From: alan.story@hertfordshire.gov.uk
To: [Planning](#)
Subject: Planning application 6/2016/1007/FULL - KFC, Comet Way
Date: 29 June 2016 09:23:00

District ref: 6/2016/1007/FULL

KFC, Comet Way

Alterations to external appearance to include, replacement entrance door and installation of new bollards and signage

drawing title
PROPOSED SITE PLAN

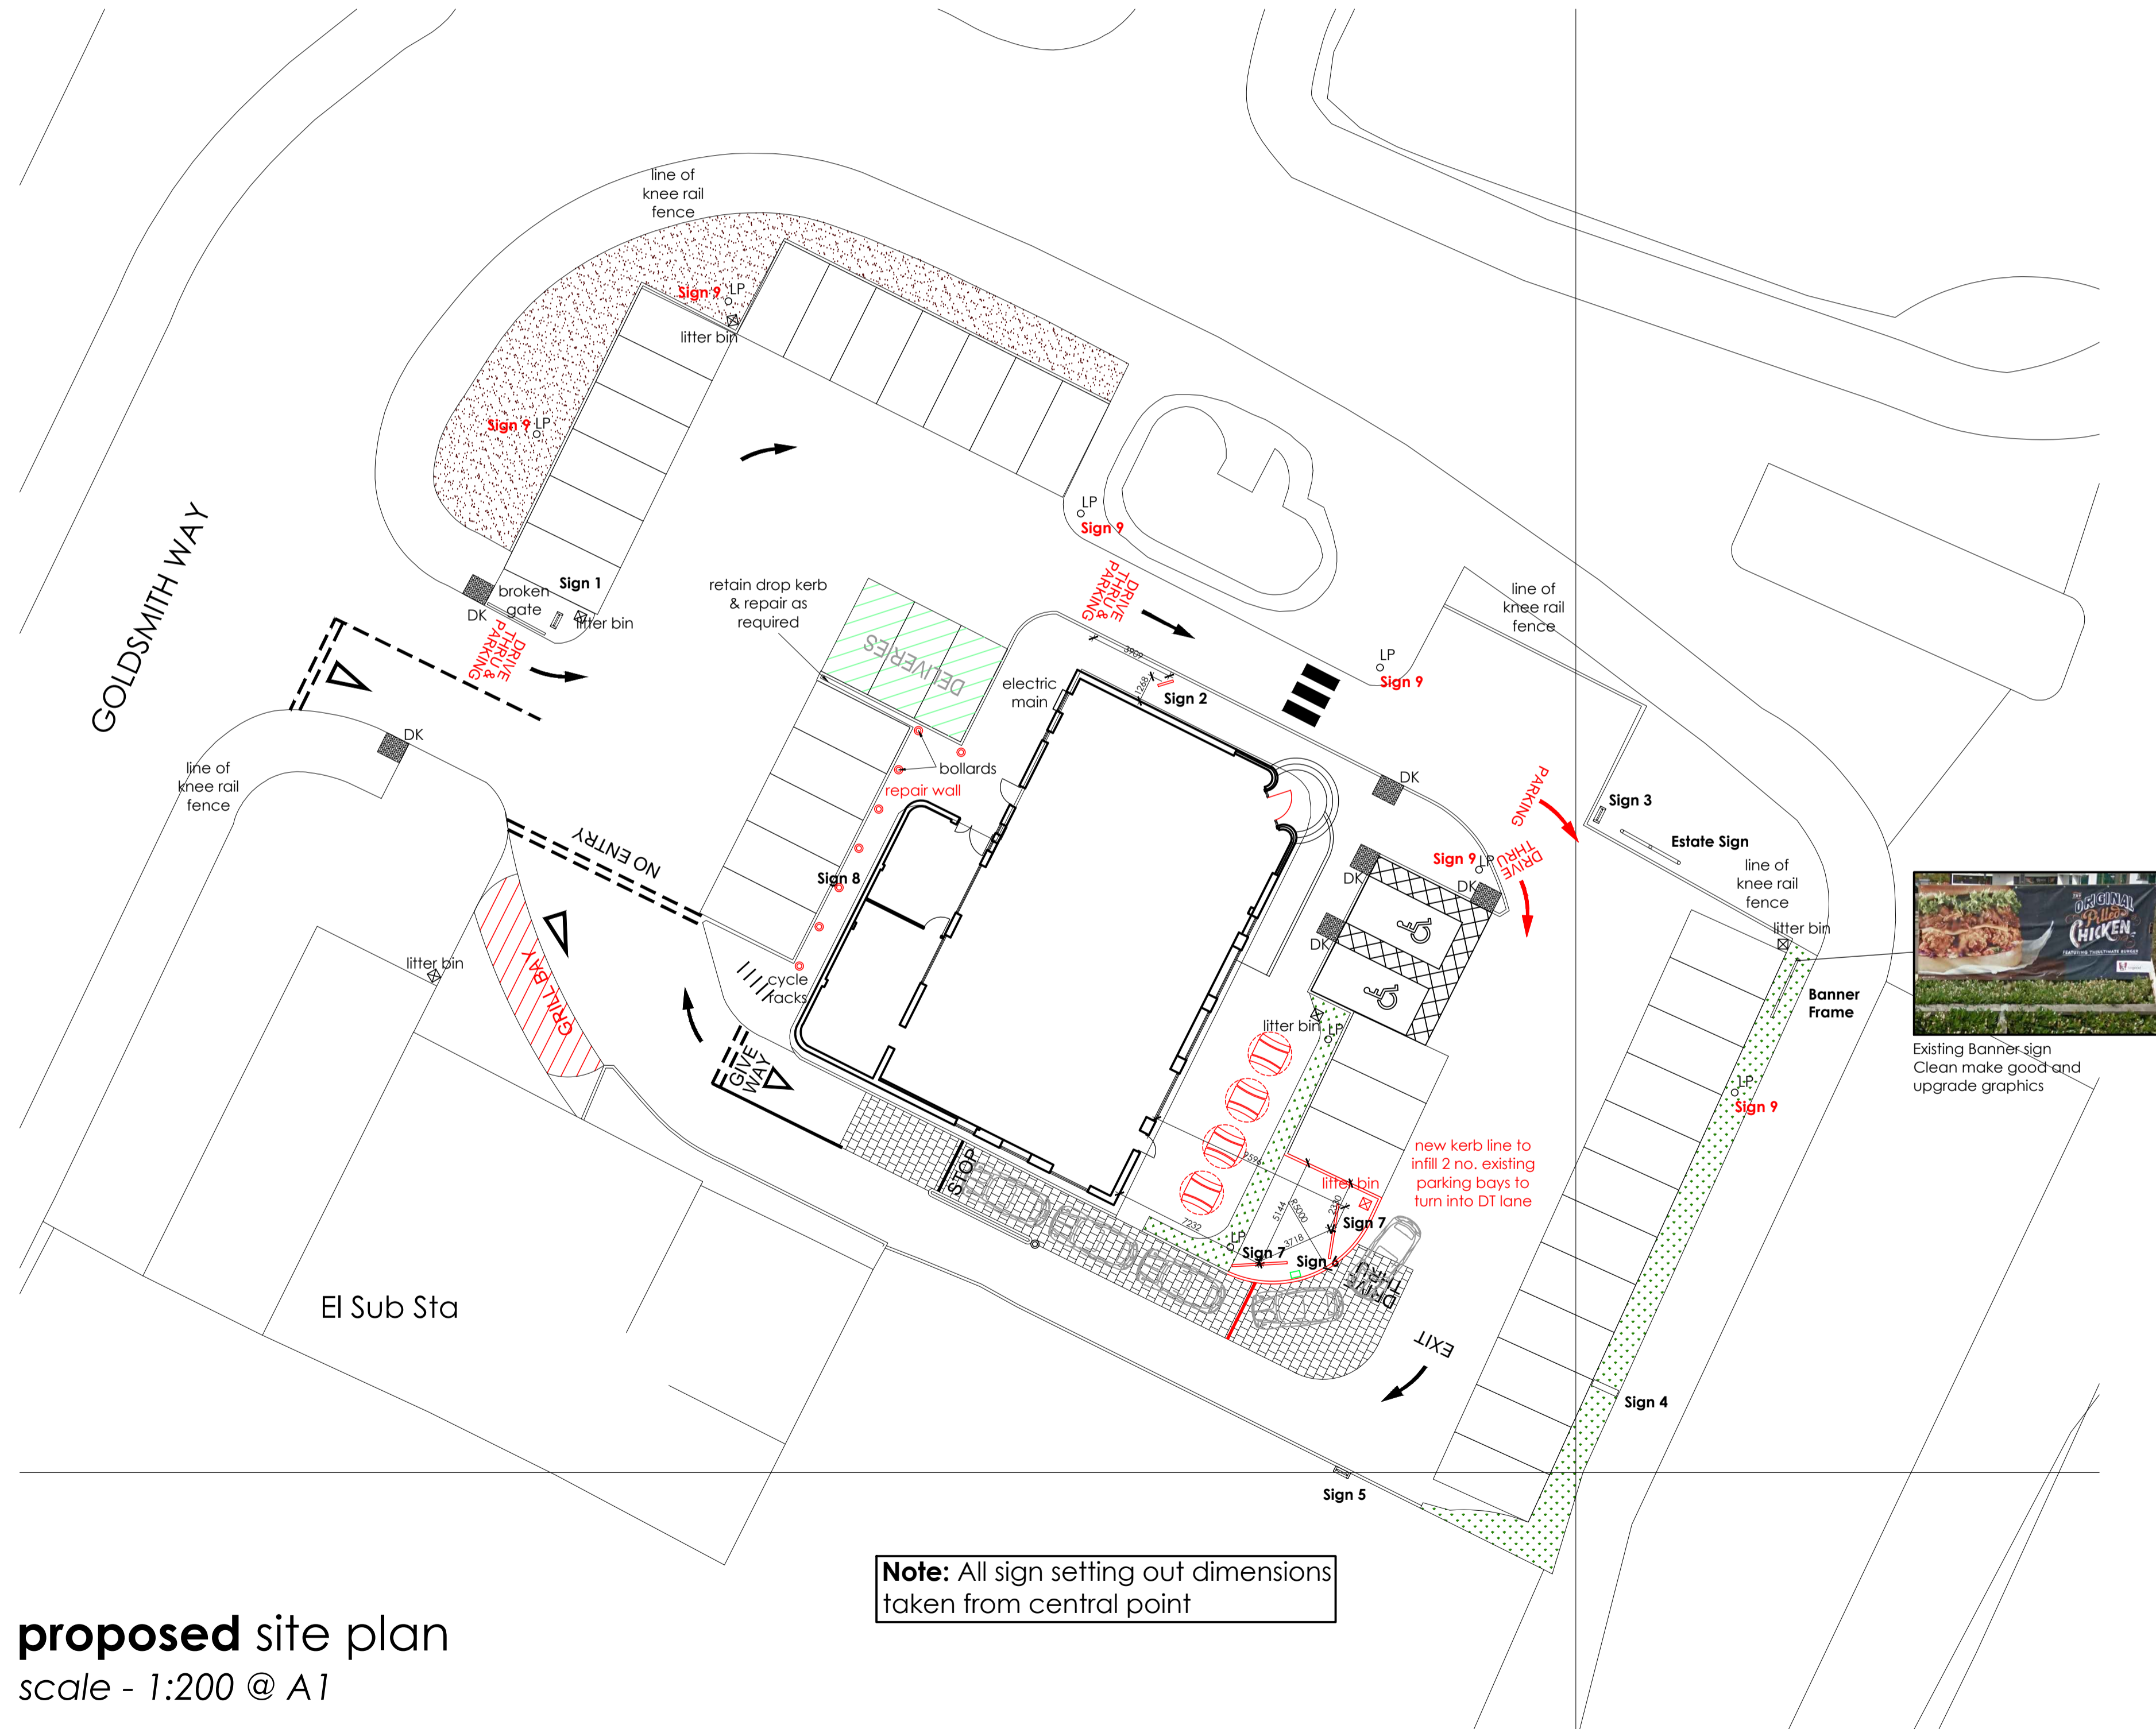
Bollards do not interfere with vehicle circulation within the site, nor materially impact on vehicle routes through the drive through facility.

Proposals do include additional carriageway markings within the car park to aide and assist route finding and circulatory movement within the site which is beneficial.
